Our Ref: FP/164/17/A 05-07-2017

Town & Country Planning (Control of Advertisement) (England) Regulations 2007 (as amended)

6 No. non illuminated oak lecturn interpretation panels with graphic panel on each. This application also lies within the parish of Bognor Regis.

Various locations in Felpham and Bognor Regis

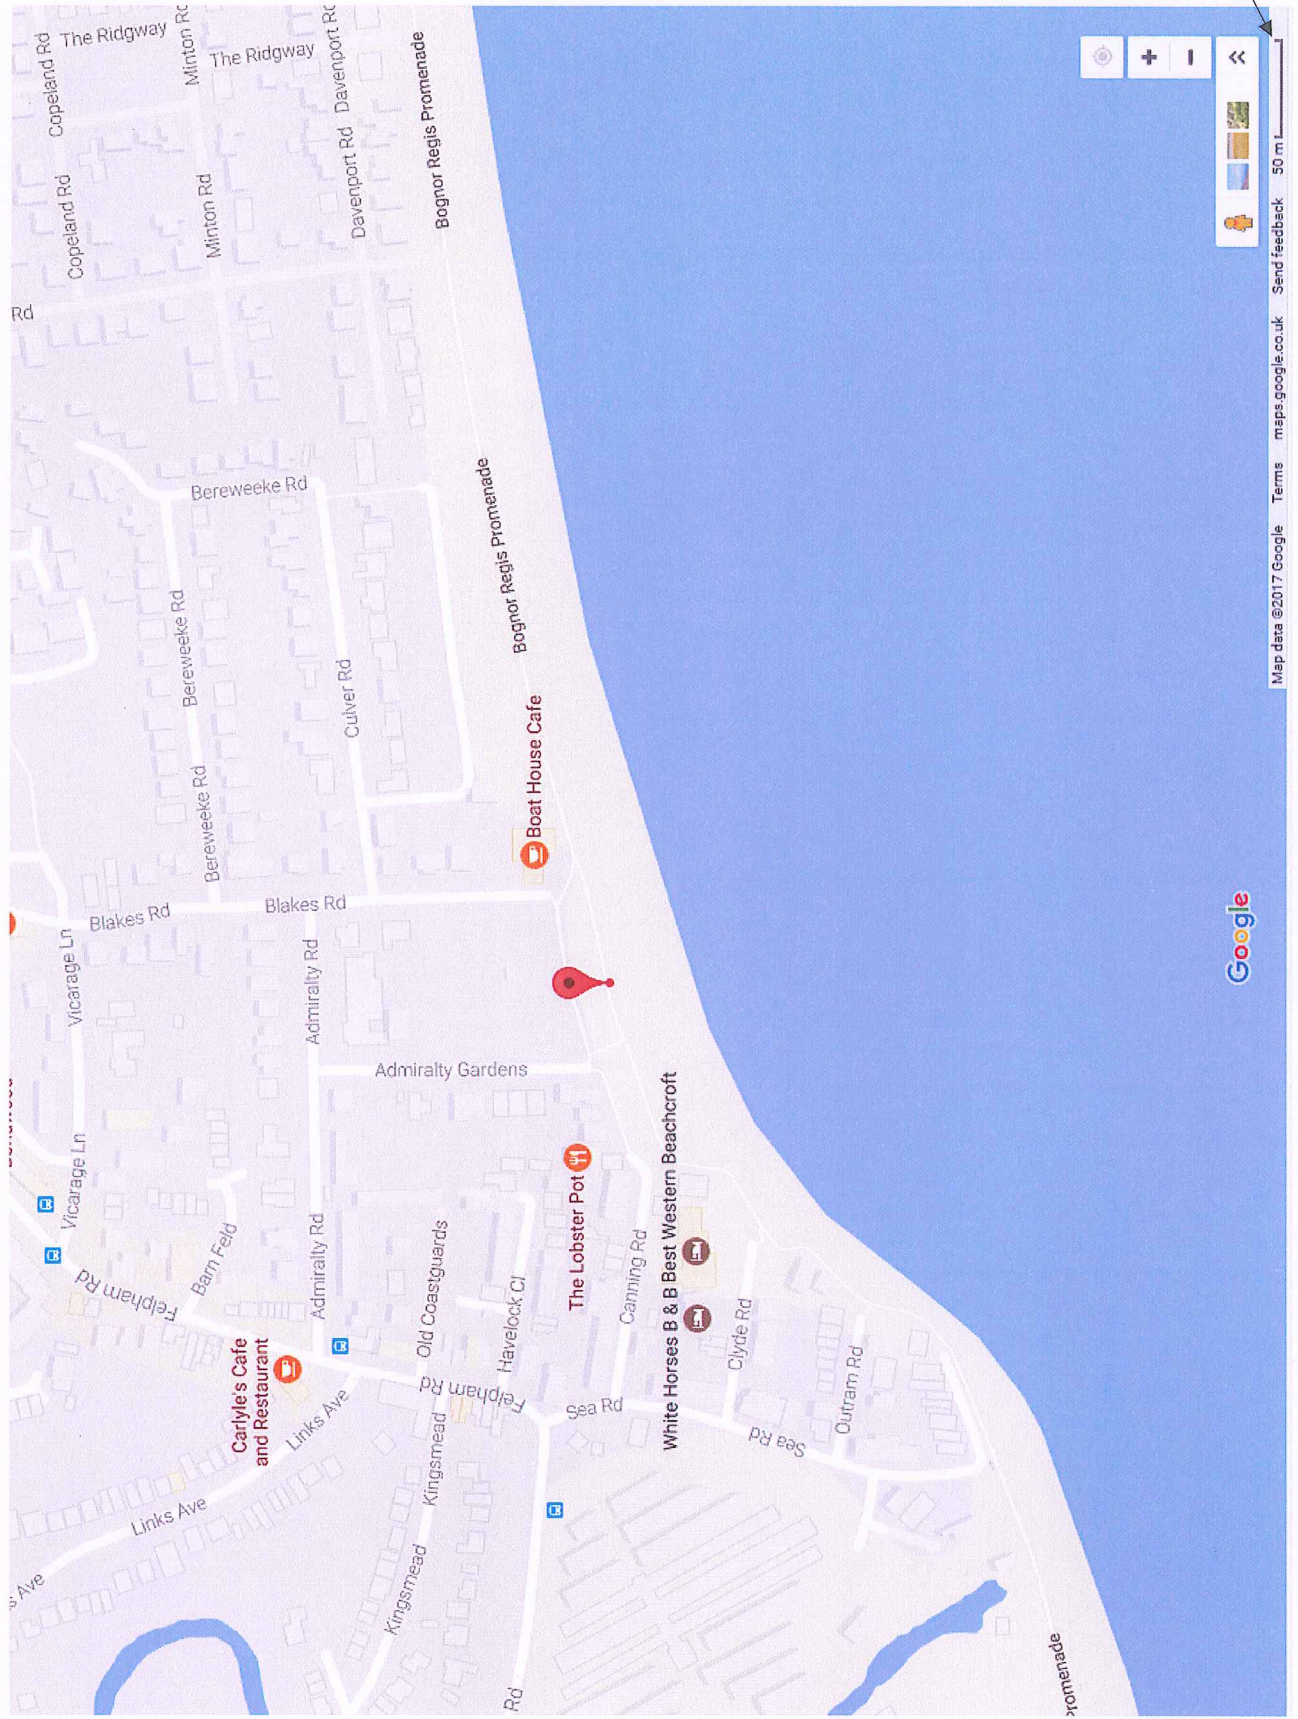
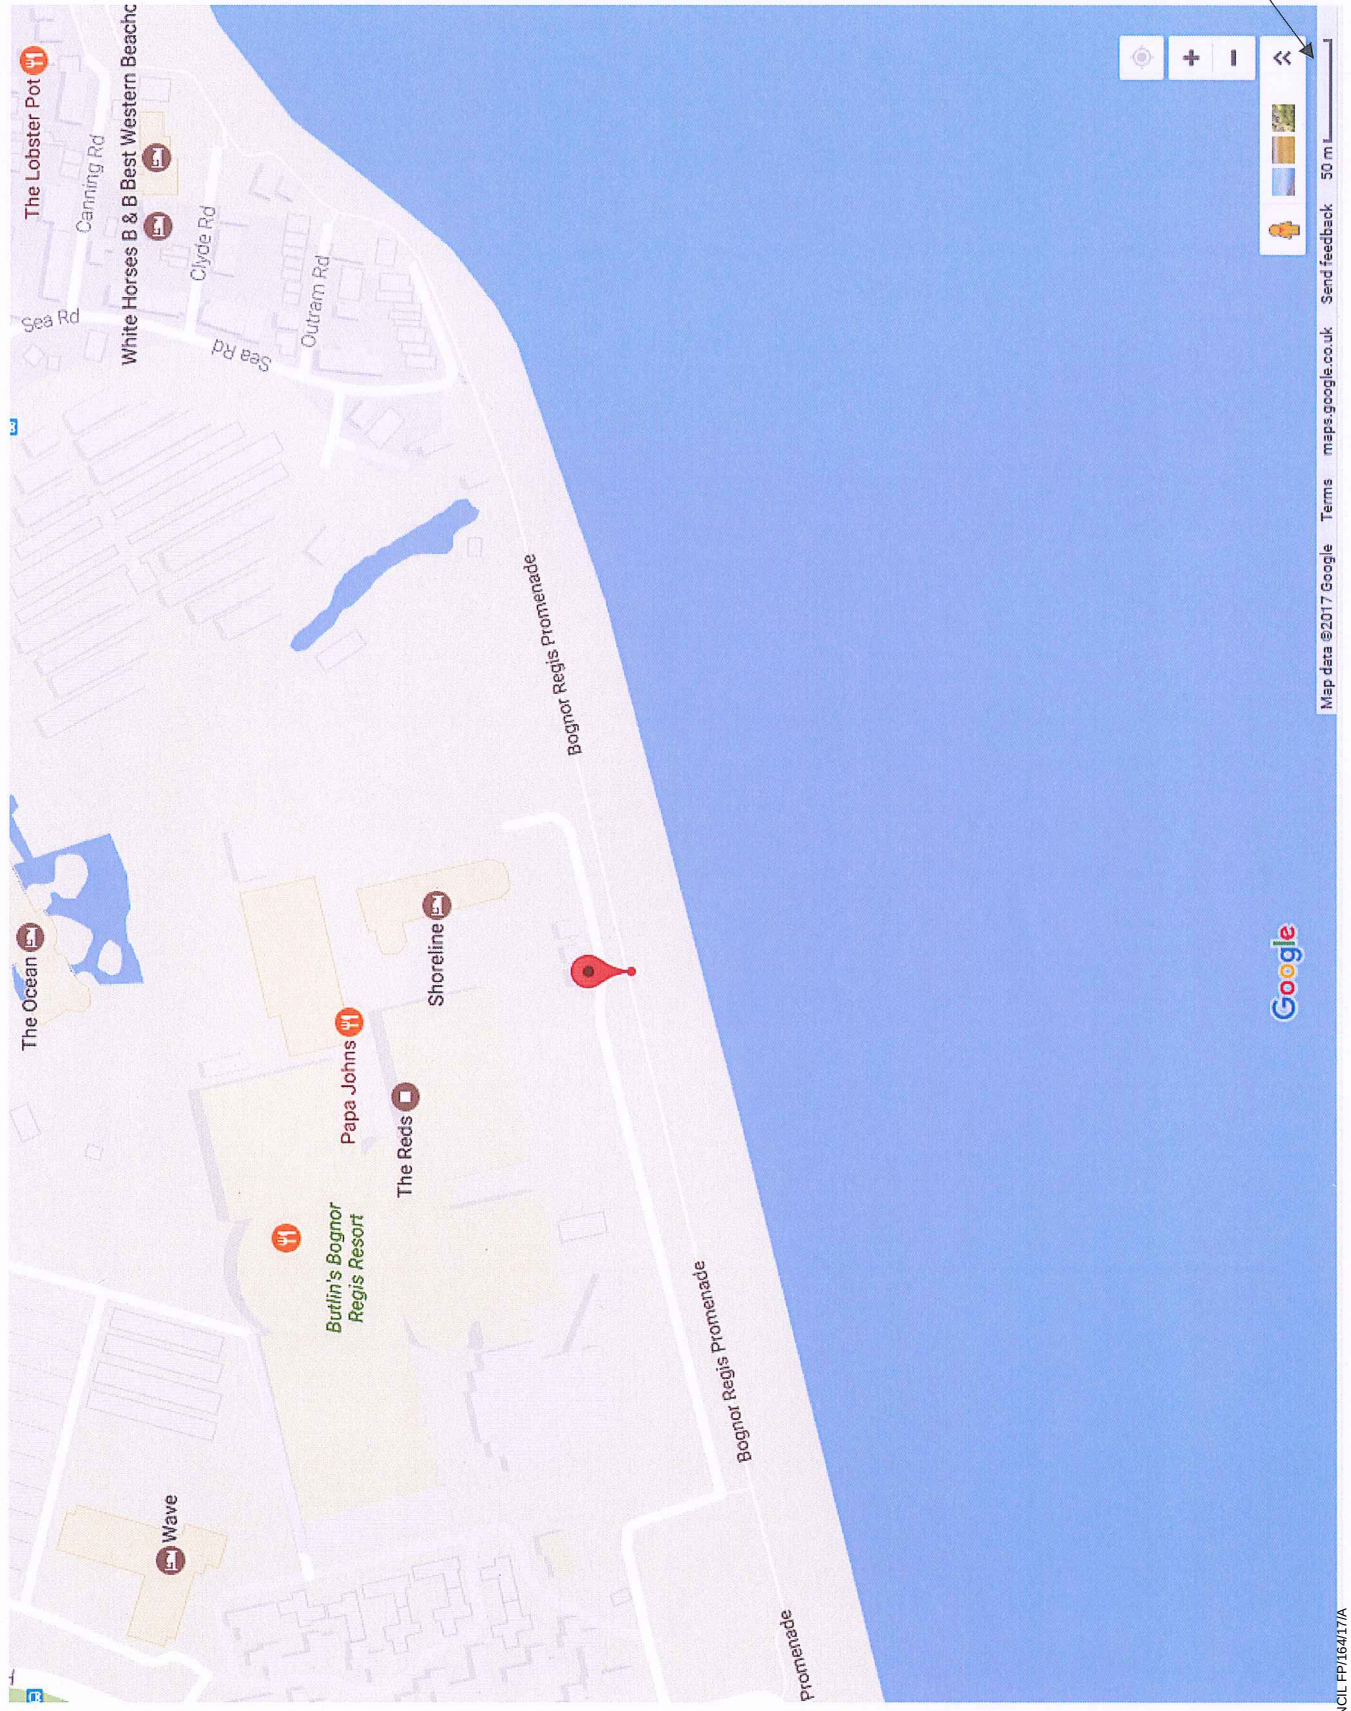
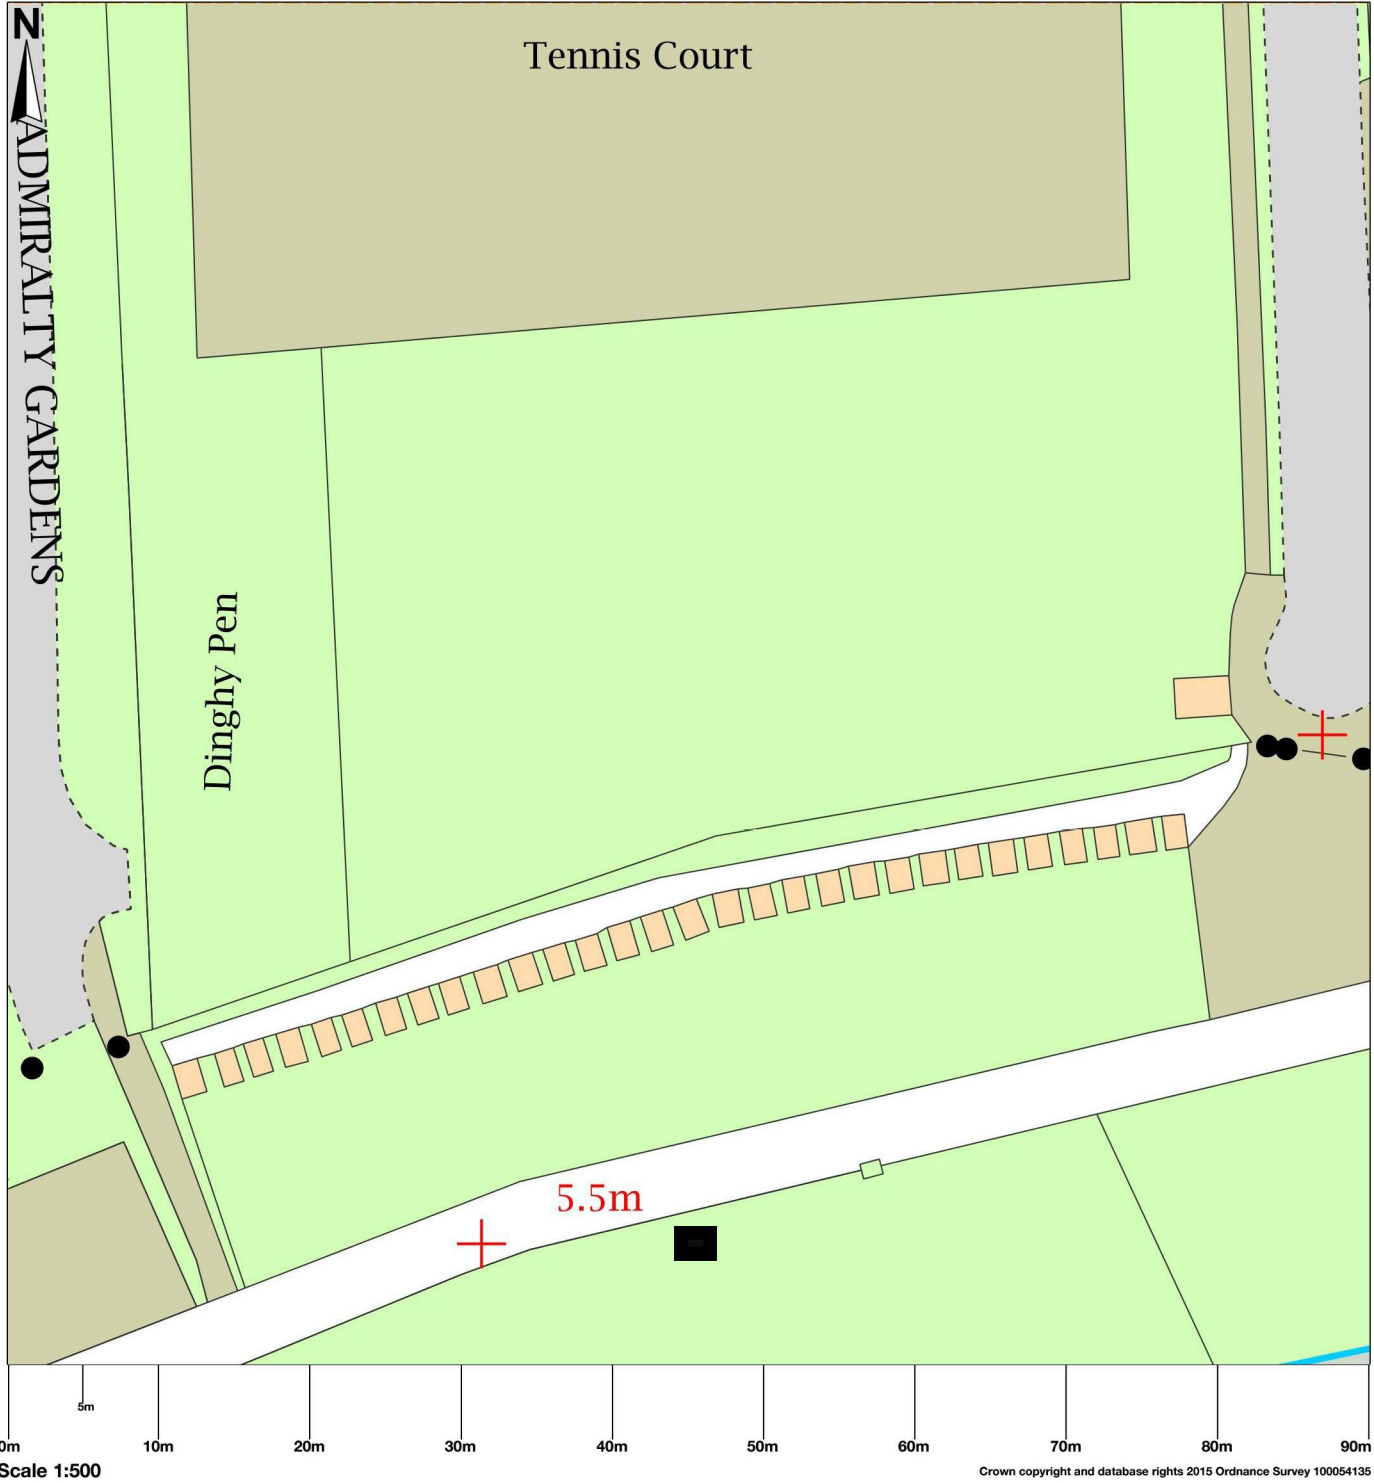
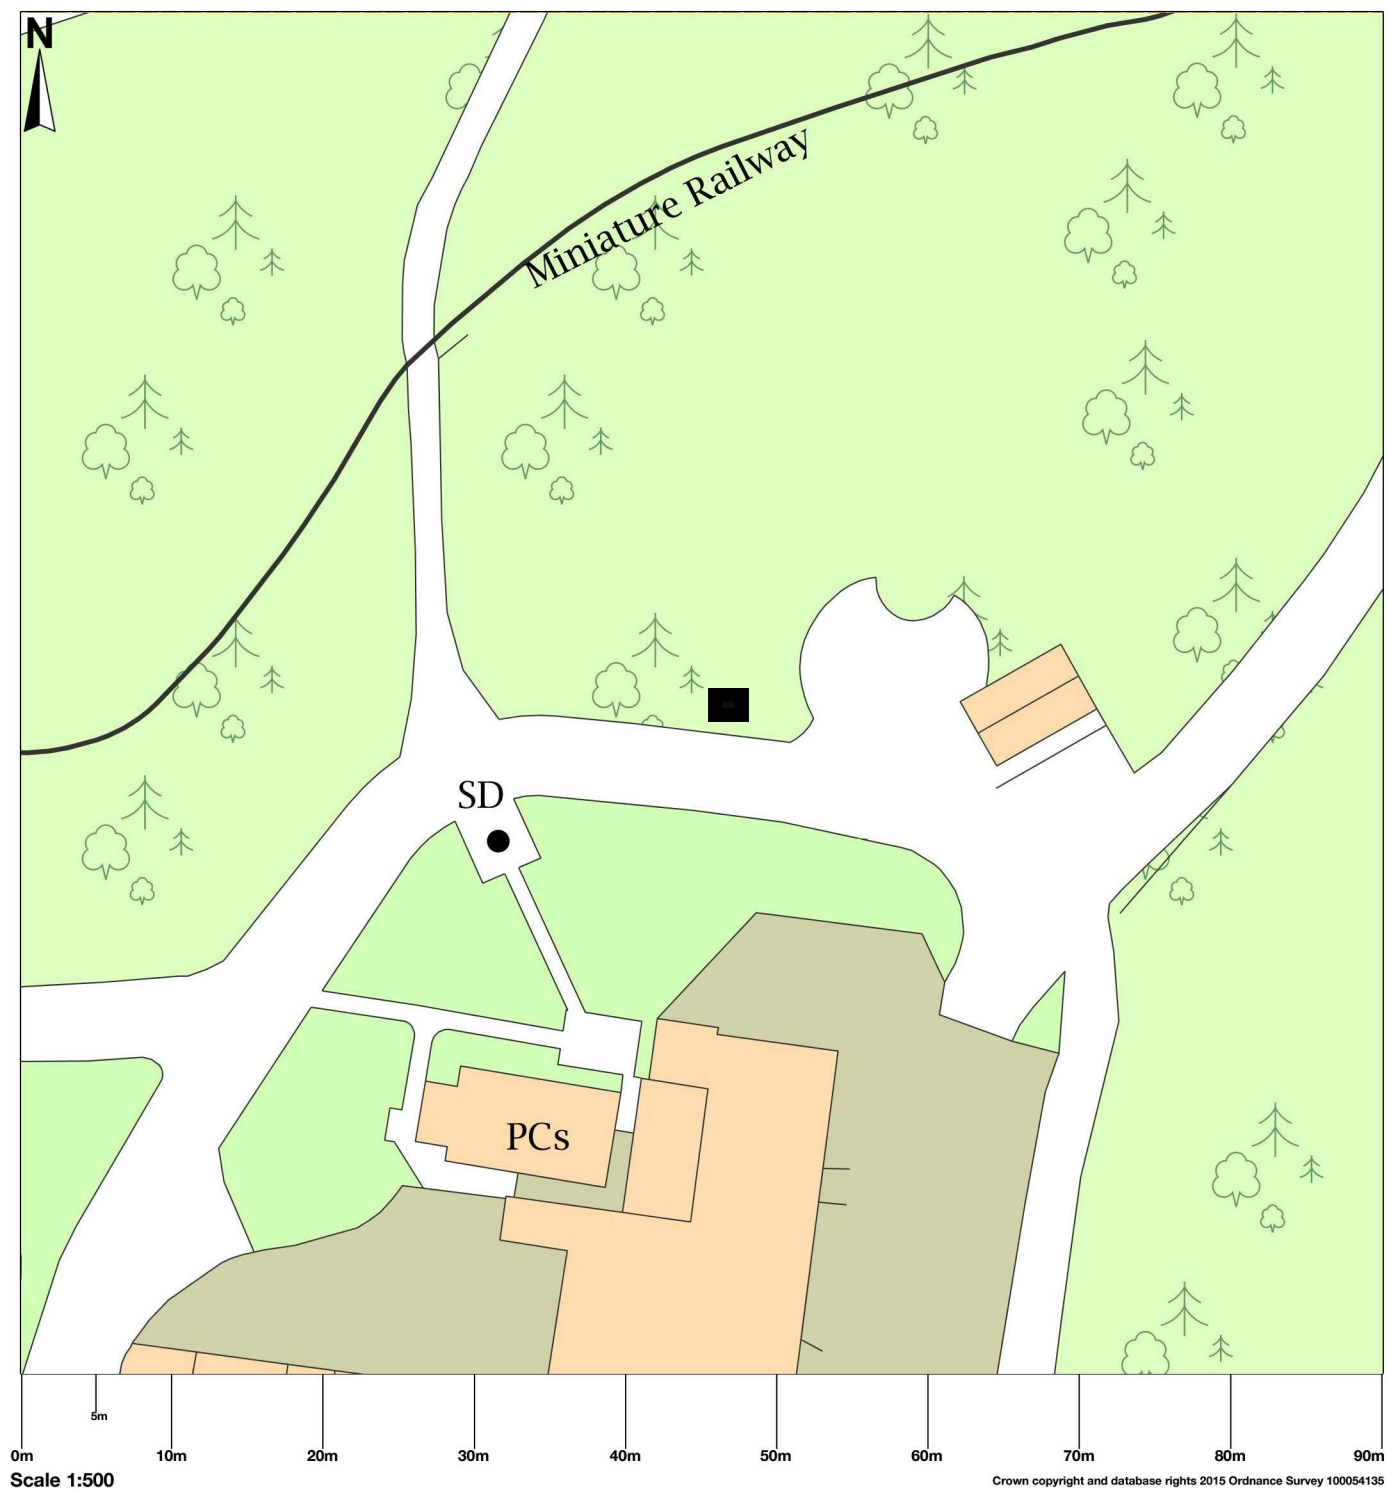
I still think the plans provided are too vague and do not clearly identify the locations. However, having looked them up on my own mapping system it appears that the two sea front panels will be located on the shingle and not on the promenade. If this is the case then I am happy for you to proceed.
